**PAVING AND DRAINAGE IMPROVEMENTS  
TO  
ADDISON ROAD  
*FROM BELTLINE ROAD TO ARAPAHO ROAD***

**BIRKHOFF, HENDRICKS & CONWAY, L.L.P.  
CONSULTING ENGINEERS  
DALLAS, TEXAS**

# **Bid 07-01 Addison Road Widening**

## **Addendum 2**

DESIGNED BY: J.W.B. PROJECT: 2002102 SHEET NO. 5
DRAWN BY: R.J.L. DATE: MAY 2005 OF 68 SHEETS

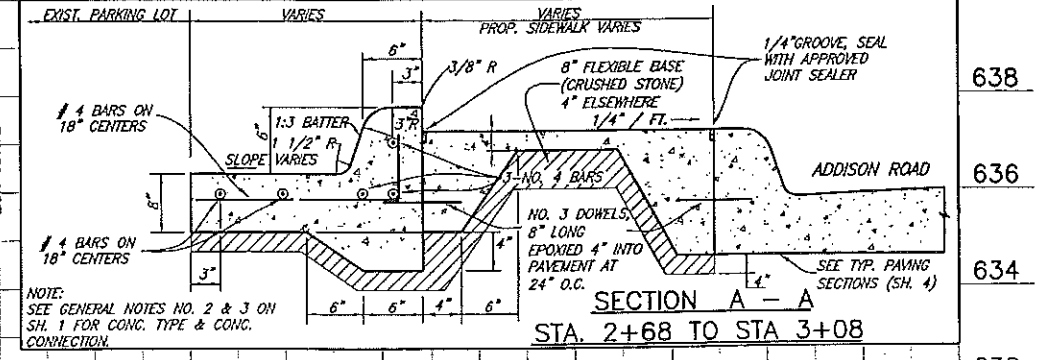
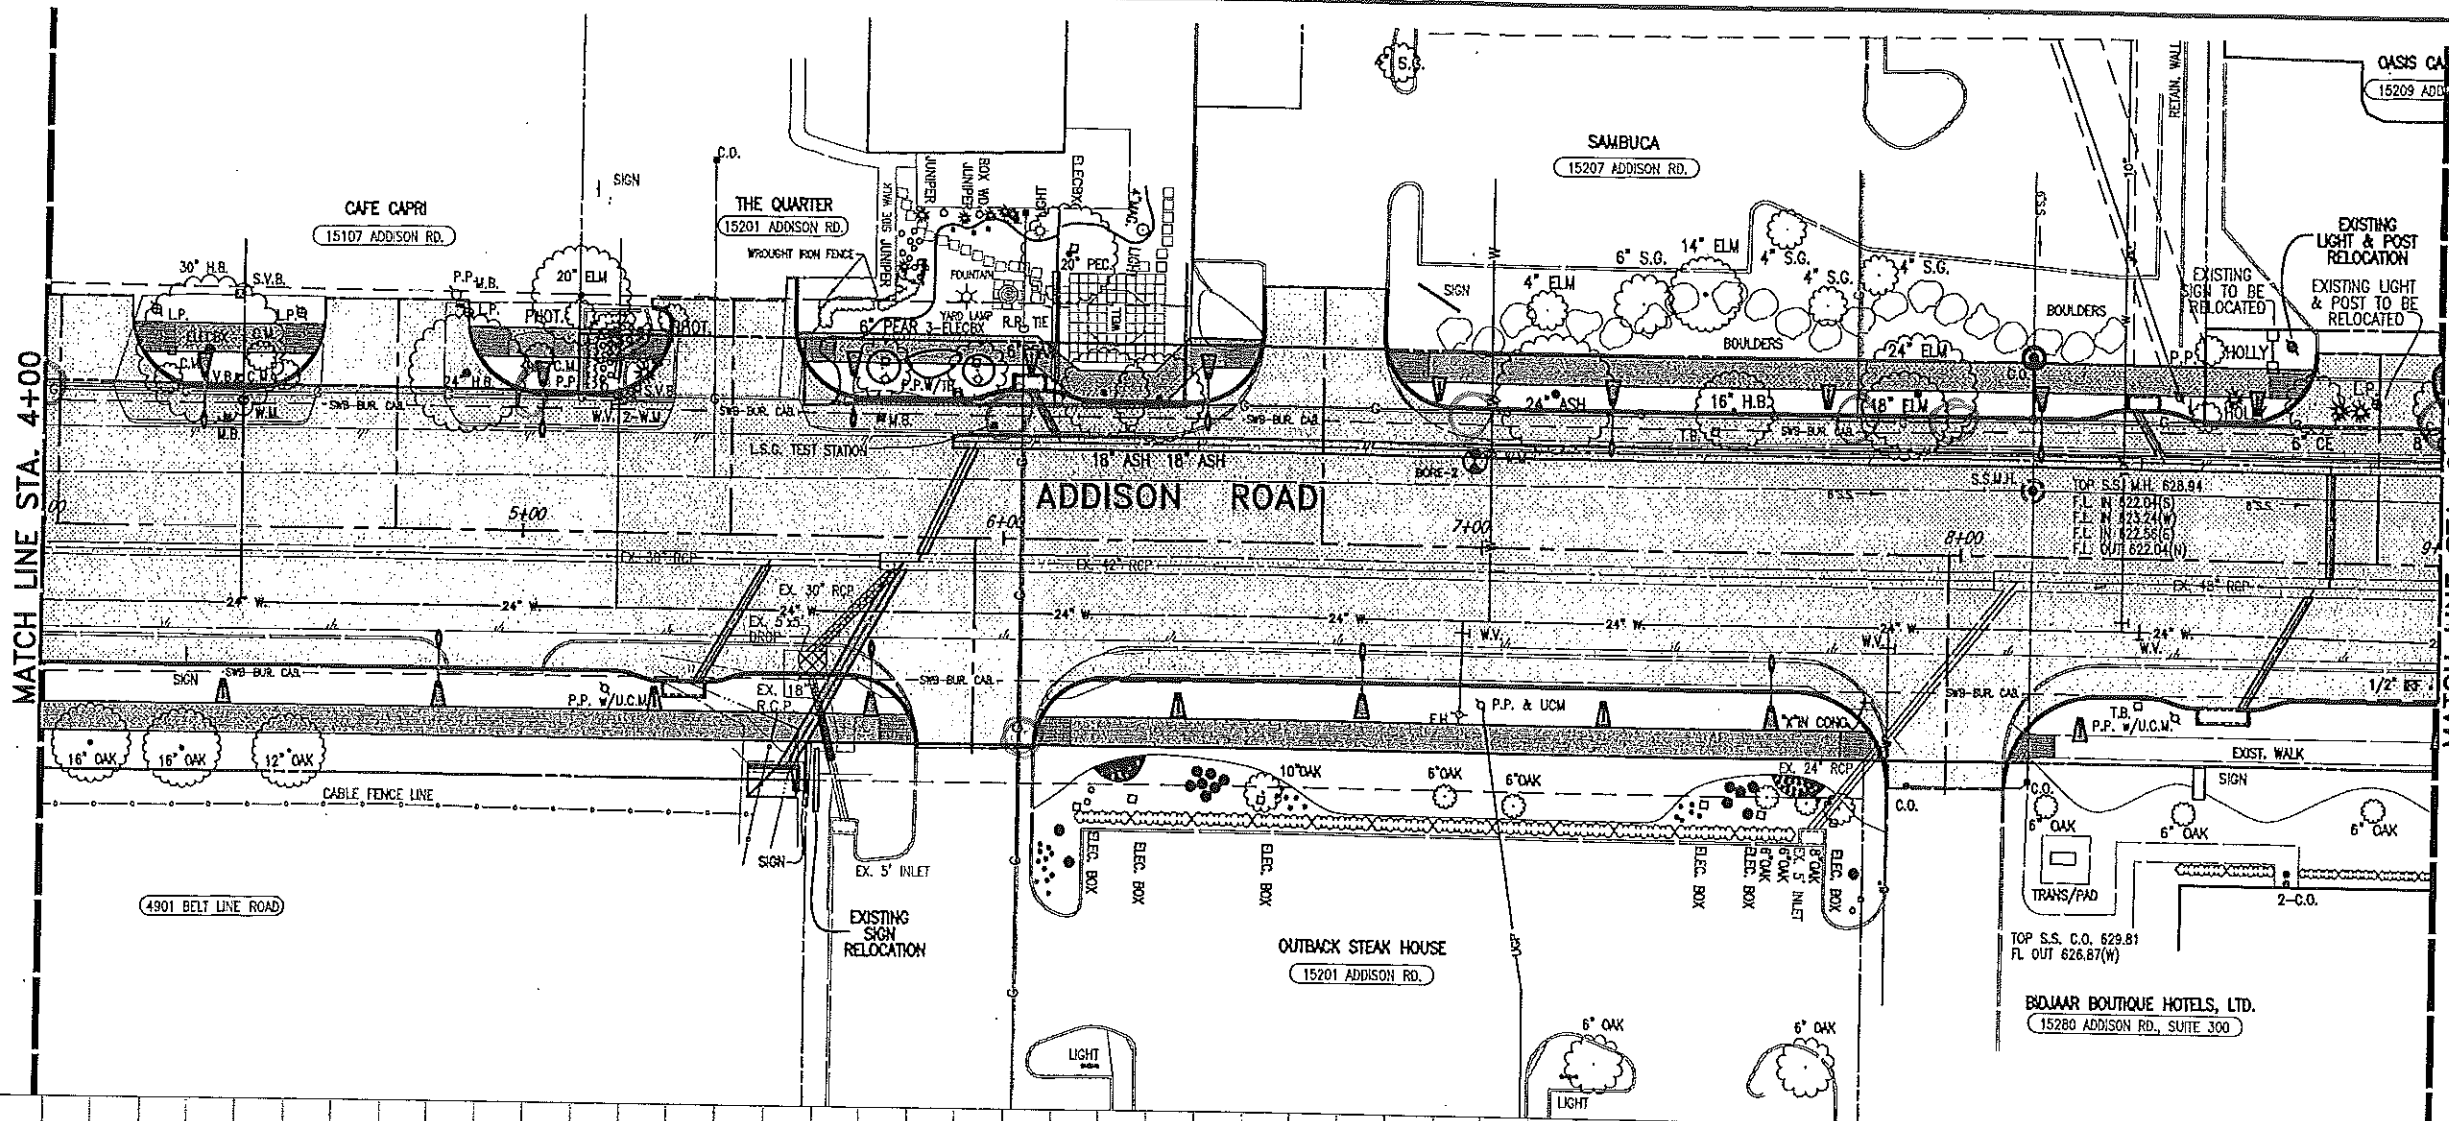
26. There will not be a bid item for the Reinforced Concrete Bridge shown on Plan Sheet #5 and detailed on Plan Sheet #23. Bidders should include the cost for the bridge in the unit cost for the sidewalk.

27. Payment for removal of cable fence as mentioned in Note A on plan sheet 5 is subsidiary to the contract.
28. A revision to Detail Section A-A on plan sheet 23 is attached herein.
